From: [REDACTED]
Sent: 14 April 2026 23:47
To: Postal Appeals <Appeals@planninginspectorate.gov.uk>
Cc: [REDACTED]
<treasurer@nottsarearamblers.org.uk>; [REDACTED] <secretary@nottsarearamblers.org.uk>
Subject: Re Great North Road Solar and Biodiversity Park, Application for a Development Consent Order (Application Reference: EN010162)

The Chair
Robin Hood Way Association.

Sir/Madam
Great North Road Solar and Biodiversity Park
Application for a Development Consent Order (Application Reference: EN010162)

PUBLIC RIGHTS OF WAY DIVERSIONS AND PERMISSIVE ROUTES PLAN

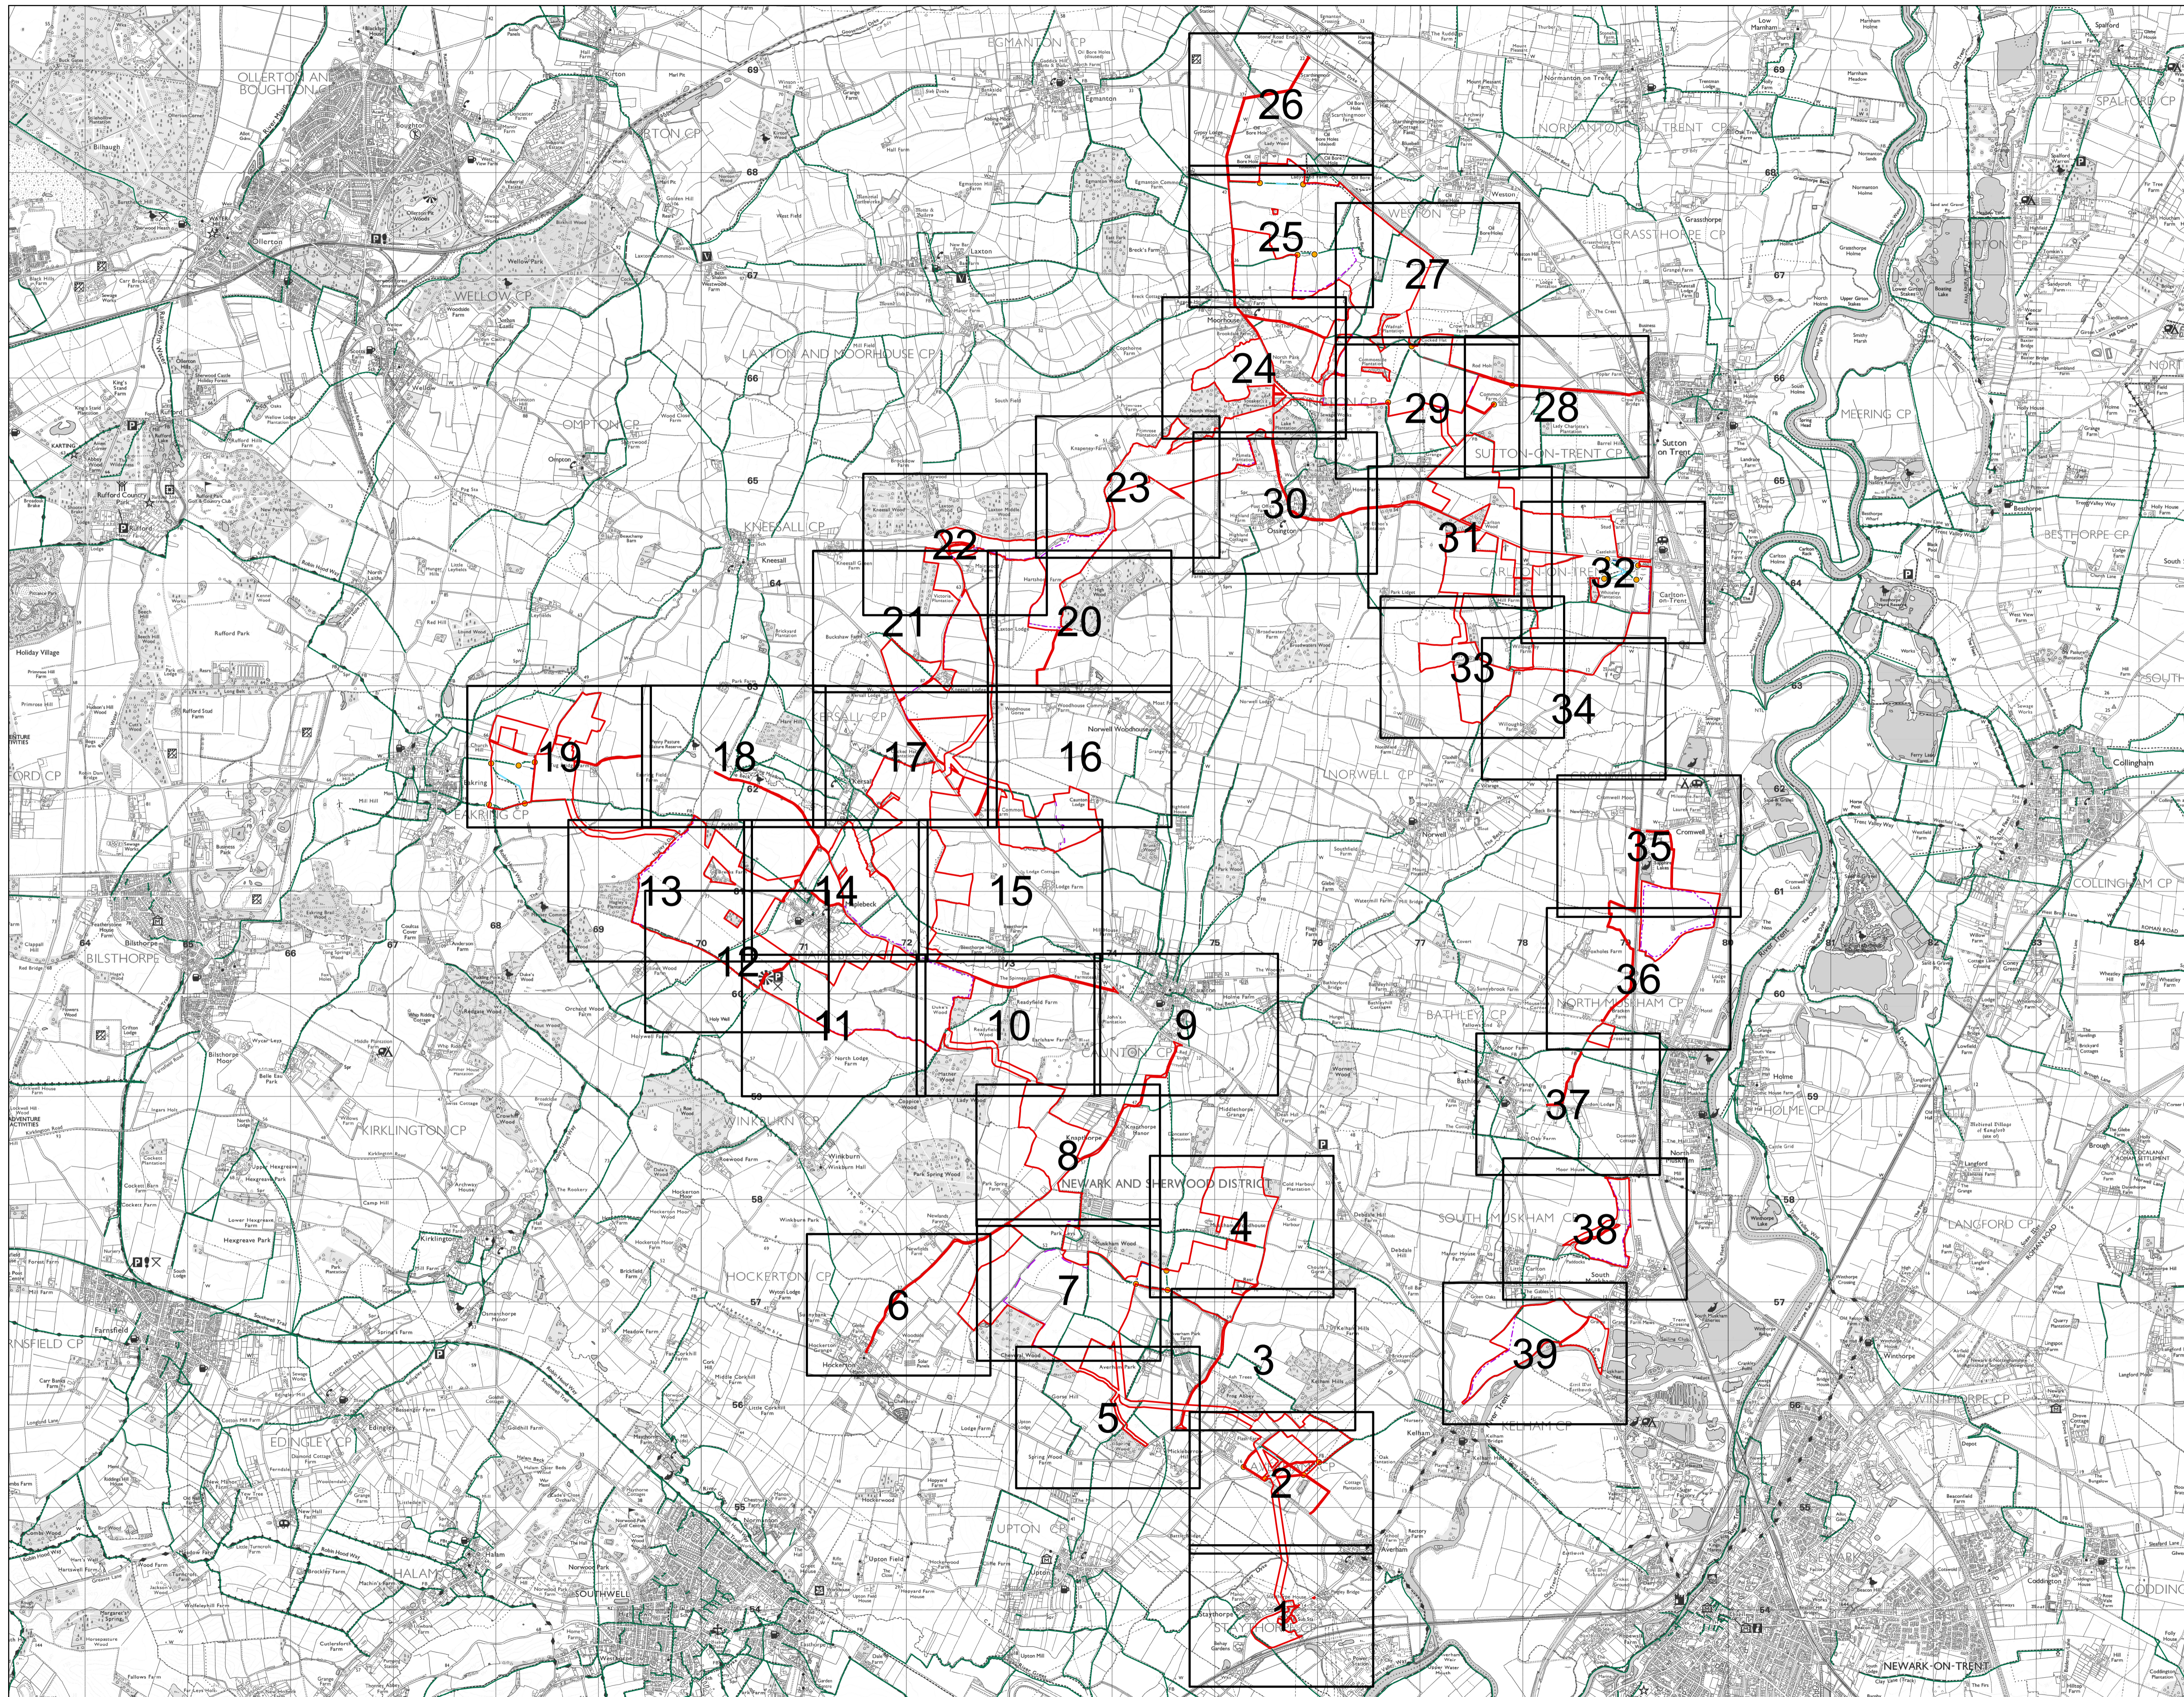
We note that this revision includes “removal of long-distance footpaths for clarity”. Long Distance footpaths are a key component of the Rights of Way network. It seems ironic that this revision should take place when the UK Government in March announced the opening of a of a sixteenth route (The Coast to Coast) to the list of National Trails.

The two long distance waymarked footpaths whose designation was removed by the applicant in the latest update are the Robin Hood Way, and the Trent Valley Way.

It is therefore imperative that these the designation of these long-distance footpaths is restored to the plans in order that the impact of what is being proposed is fully considered.
